Project Review Comments

Water Master Plan

County Water Master Plan

MP181

## CASCADING REDUCTION IN WELL YIELD

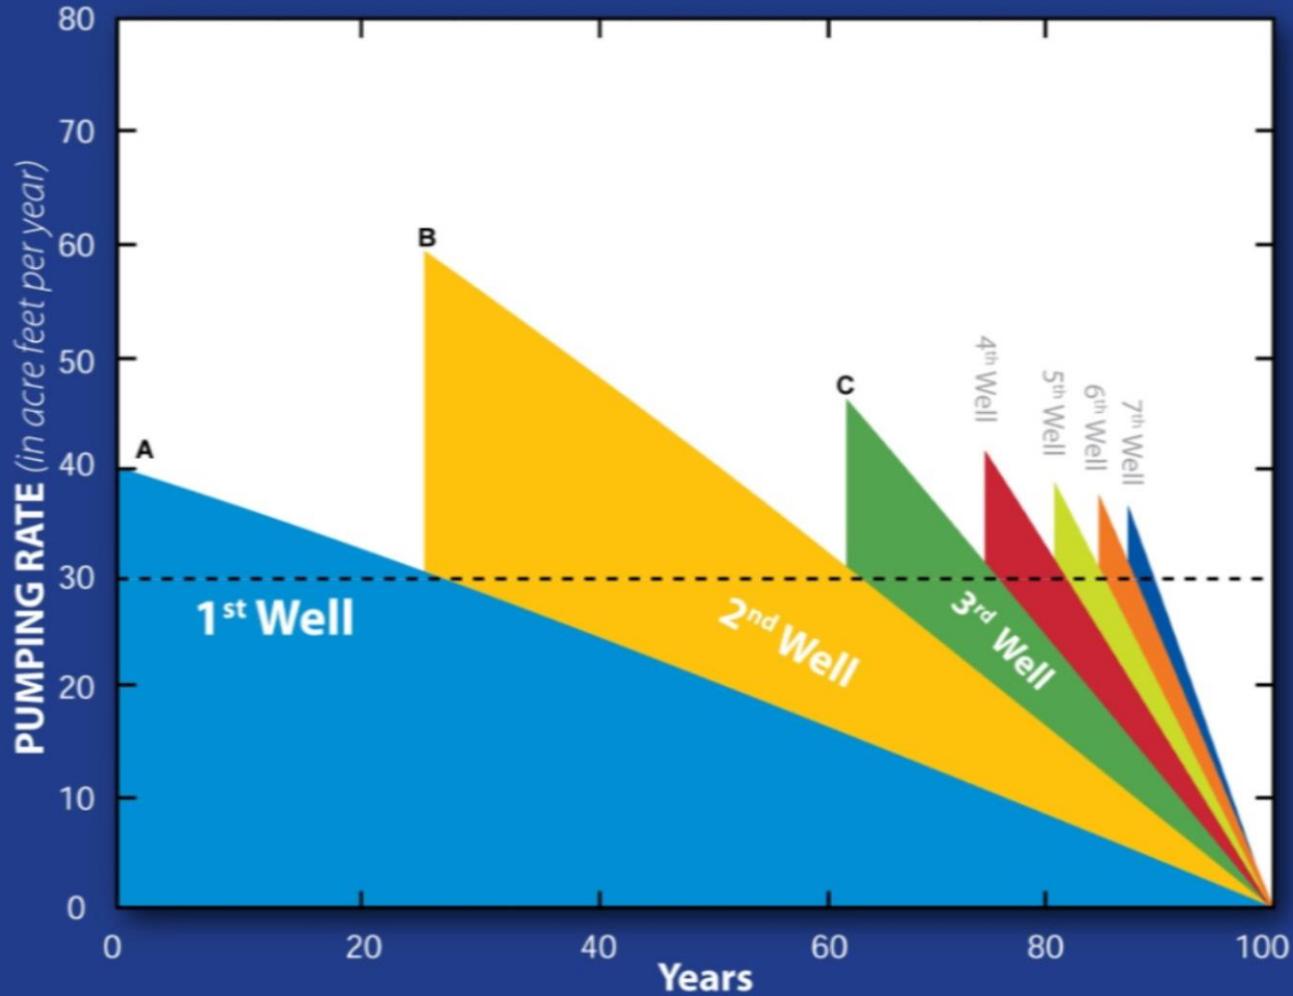
Shown is Figure 4-8 as presented in the Plan. The X-axis depicts a timeline that shows a second well is needed at about the 40th year of pumping and a third well after about 60 years of

pumping the nontributary aquifer. Attached are examples of a couple of Region 2 wells completed in the Arapahoe aquifer that have been pumping since 1972 and 1982 respectfully. Therefore, with regard to declining well yield, these wells (and likely many others) are somewhere in the “2nd Well” range and approaching the need for the 3rd Well. The aquifer conditions in Region 3 are similar with respect to declining well yields, given the thinner and tighter-grained nature of the Denver Basin aquifer in that region.

However, applying the timeline since pumping began in the Denver Basin in Region 2 to the decline in well yield depiction in Figure 4-8, the comparison of demand to supply shows a need for significant capital investment. This capital investment does not produce new water supplies, it merely sustains pumping of current sources. After about 2030, the cost curve goes up like a hockey stick to add the 4th Well, the 5th Well, etc..

Recommendation: Rather than depict Regions 2 & 3 in “blue” with a cross hatch and footnotes, either pick a new color altogether or show them as yellow. The tables could similarly include some declaration that it is reasonable to assume that

somewhere in the next 20 years many existing wells in the Denver Basin will become uneconomic to continue pumping. Therefore, available supplies are reduced in 2040 by 30% and in 2060 by 50%. The graphics can then show that shortfall in a fashion similar to Region 1. In other words, YES, we need more water and we have 20+ years to figure it out.
